DELEGATED HOUSEHOLDER DECISION

Item No. Report of the Head of Planning & Enforcement Services**Address** 6 PRIORY CLOSE RUISLIP MIDDLESEX**Development:** ERECTION OF A TWO STOREY FRONT EXTENSION**LBH Ref Nos:** 58507/APP/2003/2492**Drawing Nos:** 2704/1 Rev. B**Date Plans Received:** 23/10/2003**Date(s) of Amendment(s):** 10/06/2010**Date Application Valid:** 23/10/2003**1. CONSIDERATIONS****1.1 Site and Locality**

Planning permission is sought for a two storey front extension including a double storey bay. The proposed extension would have a width of 3m, a depth of 2.65m inclusive of the 2 storey bay window and an overall height of 2.6m. The proposed two storey extension would enable the enlargement of the study at ground floor level and the second bedroom at first floor level.

FRONT ELEVATION

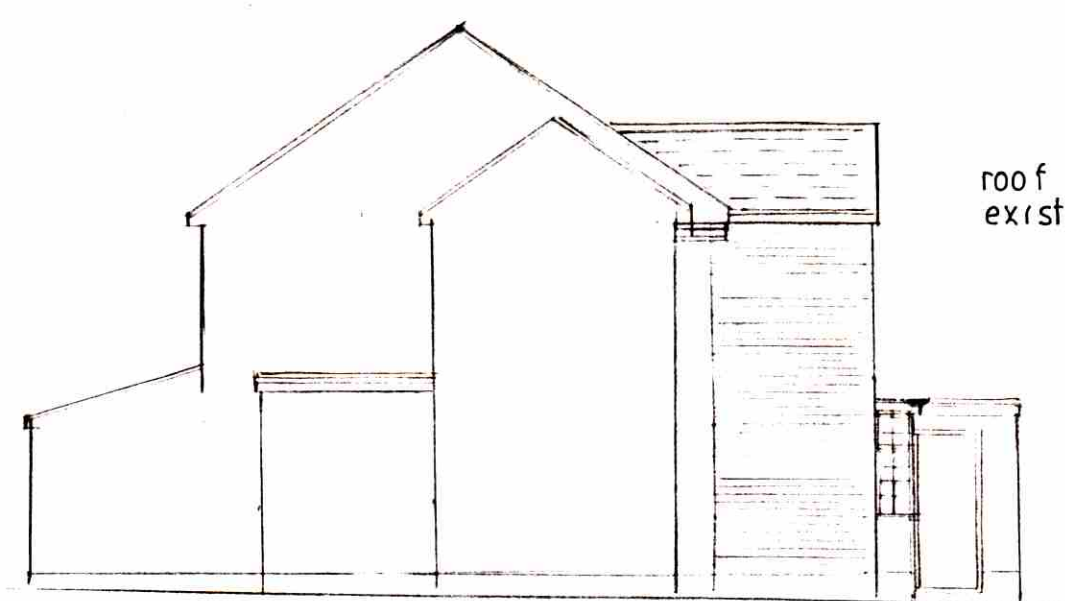
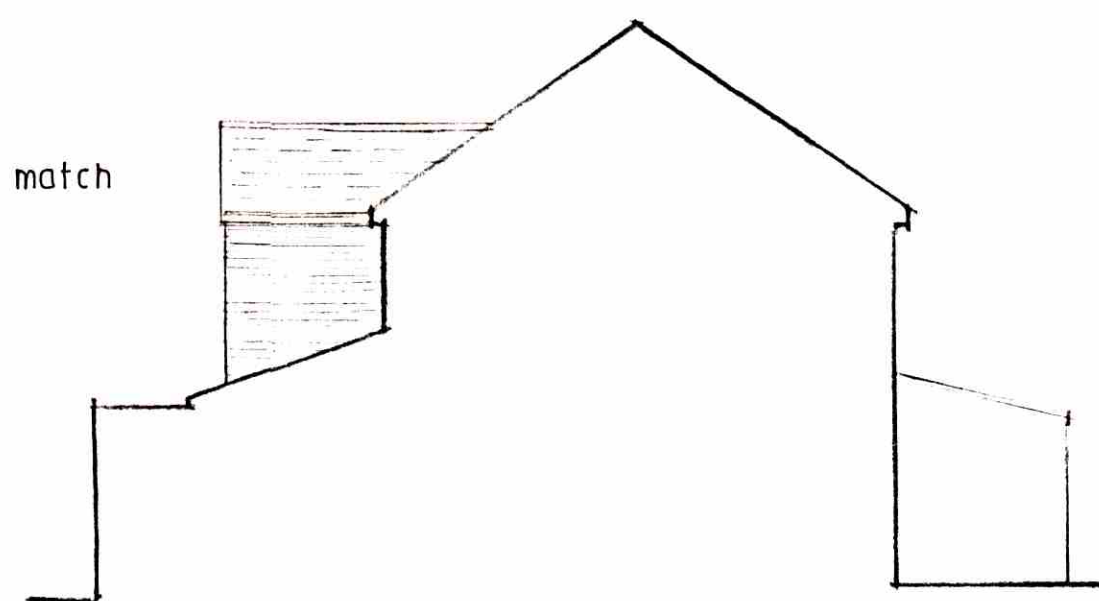
In terms of streetscene appearance the front extension would be proportionate to the design of the house. The extension is considered in terms of design detailing, scale and siting would maintain the overall appearance of the house and would not unbalance the relationship to No 7 the adjoining semi-detached house or be out of harmony with the wider streetscene.

The Conservation Officer has raised no objection in principle to the scheme as the extension is considered would have little or no impact upon the character or appearance of the Conservation Area. A condition would be attached to any planning permission

issued which would ensure that the external materials used for the proposed development would match those already used on the existing house. In summary the design of the proposed development would be a sympathetic addition to the built character of the neighbourhood.

Samples of all materials and finishes to be used for all external surfaces of the building shall be submitted to and approved in writing by the Local Planning Authority before commencement of any works.

SITE PLAN showing GROUND FLOOR PLAN

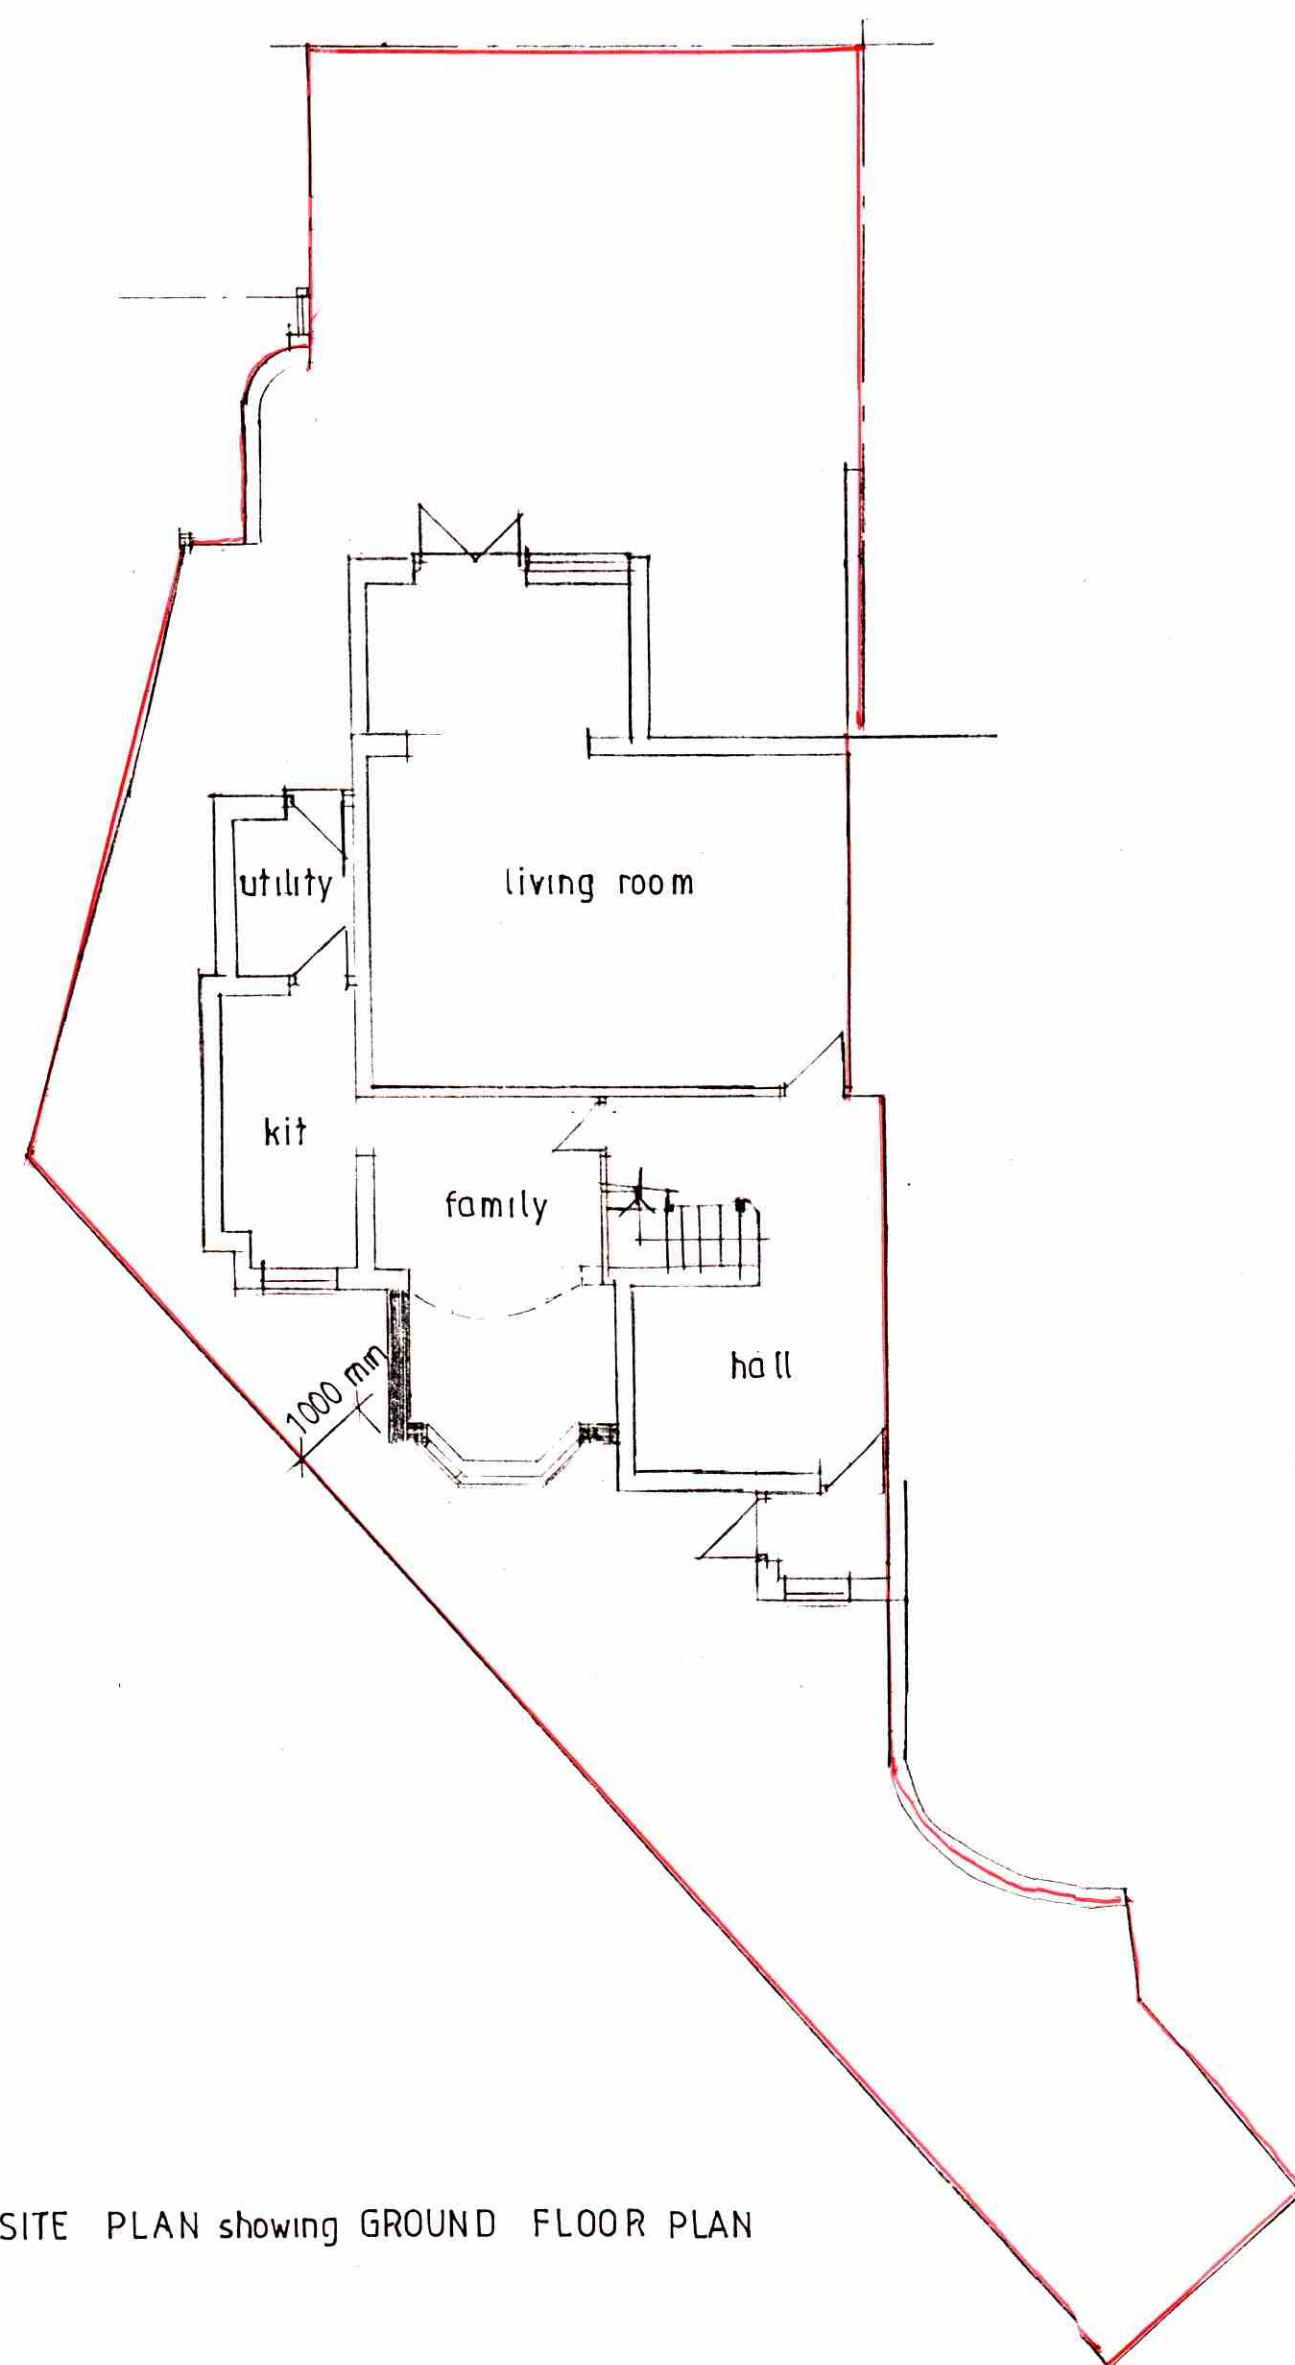
The front extension would maintain a minimum 1 metre gap to the site boundary with No 5 Priory Close (a new dwelling house built to land formerly serving No 4 Priory Close) and in visual aspect terms it is not considered the front extension would be over-dominant to this recently built detached house.

In respect of the potential amenity issues to neighbours the extension would be set in line with that of the principal elevation of 5 Priory Close. A minimum 1 metre gap to the side boundary would be retained thereby avoiding an undue degree of overbearing to this adjoining house. The proposed extension would enable adequate levels of sunlight and daylight to access the site and adjoining properties at No 4, 5 and 7 Priory Close. It is not considered the proposed extension would accentuate any issues of privacy to occupants of adjoining properties as the extension faces onto Priory Close and would not overlook, the private rear amenity space of the adjoining properties at No 4 or No 5. The angle of outlook between the ground and first floor windows of the proposed extension and the street facing windows at No 5 Priory Close is considered too oblique to cause any unacceptable issues of overlooking to these habitable rooms. The proposal therefore complies with Policies BE20 and BE24.

The development shall not be carried out otherwise than in strict accordance with the plans hereby approved, including maintaining at minimum a clear 1 metre gap to the southern site boundary, unless consent to any variation is first obtained in writing from the Local Planning Authority.
